December 14, 2017

RE: North Town Plaza Tract A-1 – 5901 Wyoming Blvd. NE
Request for Certificate of Occupancy
Hydrology Final Inspection- Disapproved
Engineer's Stamp Date: 12/09/2017 (E19D033)
Certification Dated: 12/12/17

James D. Hughes P.E.
Principal Engineer, Planning Dept.
Development Review Services

C201

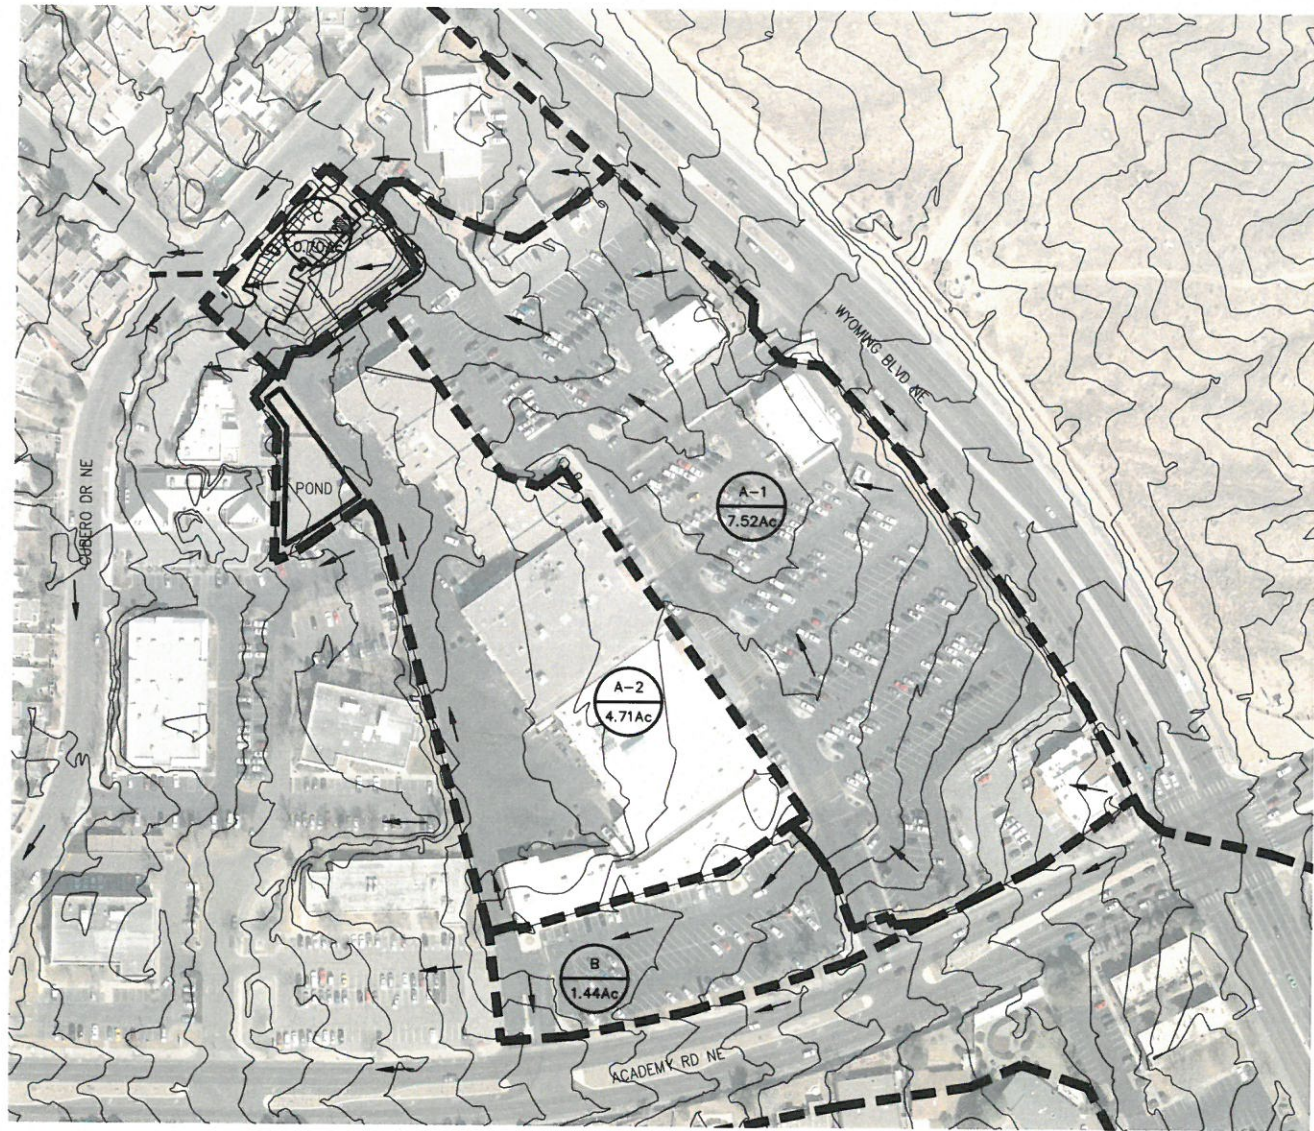
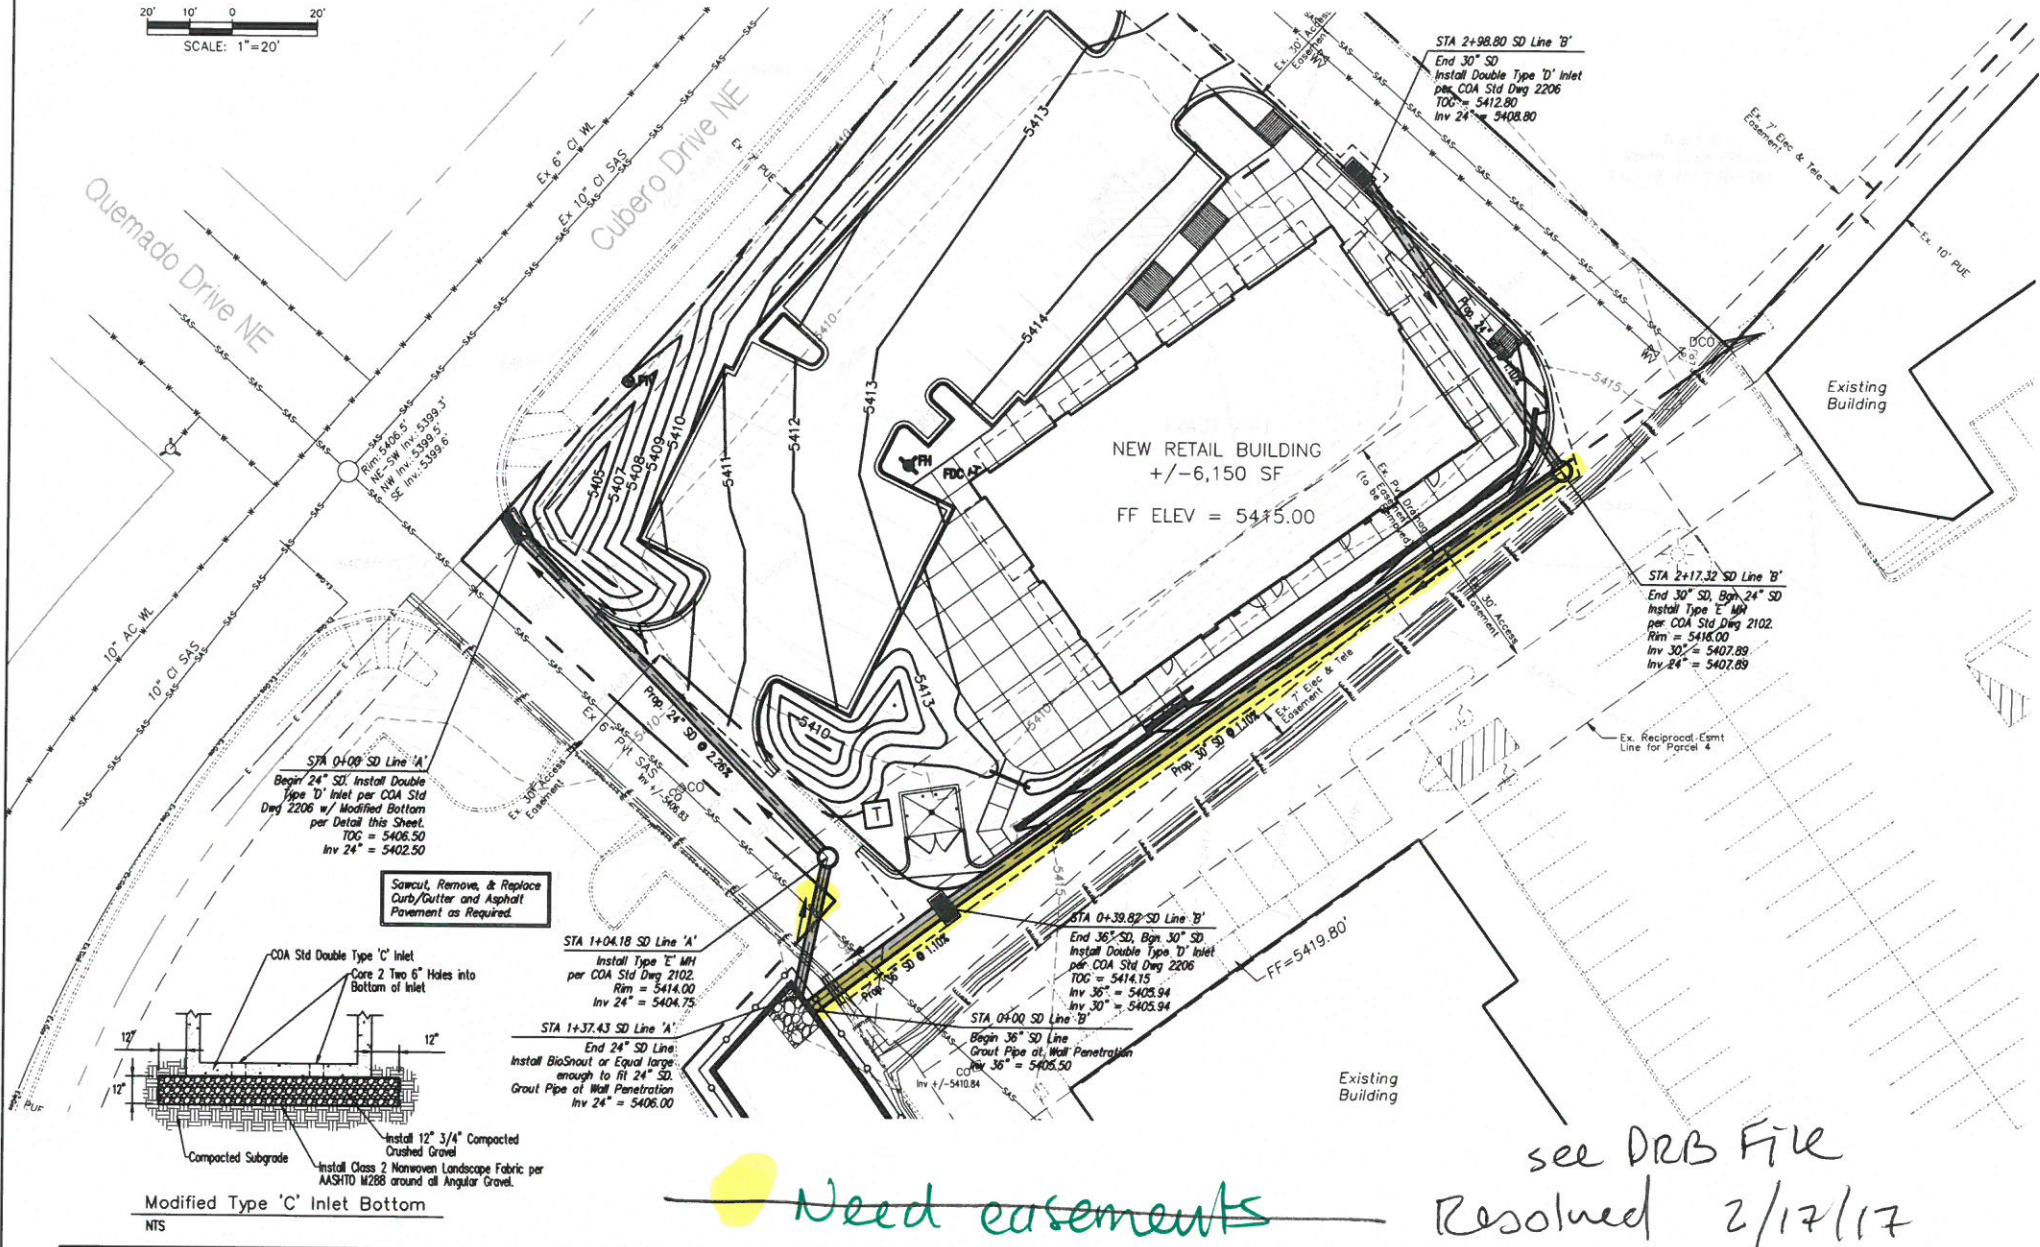
Based upon the information provided in the submittal received on 11/27/17 the above-referenced plan cannot be approved for release of Certificate of Occupancy by Hydrology. The changes made to the approved grading and drainage plan are too extensive to be made on the Engineer's Certification. A revised Grading and Drainage Plan (showing the storm drain on the north side of the building instead of the south side) must be submitted and approved first, and then the Engineer's Certification can be made on the newly approved G&D Plan. All sheets of the plan should be resubmitted and the changed pipe locations should be shown on all sheets. For revised G&D Plan approval the following will need to be addressed.

1. The HGL should be shown on the new pipe profiles with elevations, flow rates, and velocities ladled. Provide sufficient details of the "snorkel" pond outlet structure to demonstrate that it has capacity to discharge the peak flow rate. All engineering calculations must be bound into a report and stamped by a registered professional engineer
2. Include engineering calculations in the report to demonstrate adequate downstream capacity to justify increasing the existing allowable pond discharge from 9.6 cfs to 26 cfs from the new pond. Digital copies of all models should also be included with the revised G&D submittal.

1. After the revised G&D Plan has been approved, the Engineer's Certification should be added along with as-built elevations at all drainage structures, inlets, water blocks, and the ponds
2. A new Drainage Covenant for the new pipes and pond must be recorded and the old drainage covenant should be released. Two Drainage Covenants may be required, one for each of the separate parcels. The parcels and easements should show up on the G&D Plan and on the exhibits included with the covenants.
3. Provide proof that the existing private drainage easement has been removed from where the building is located, and a new easement has been granted on all of the new storm drain locations.
4. Provide proof that the retaining wall/piling around the pond has been permitted for construction and accepted by the City, and note the change from wall to piles on the plans.
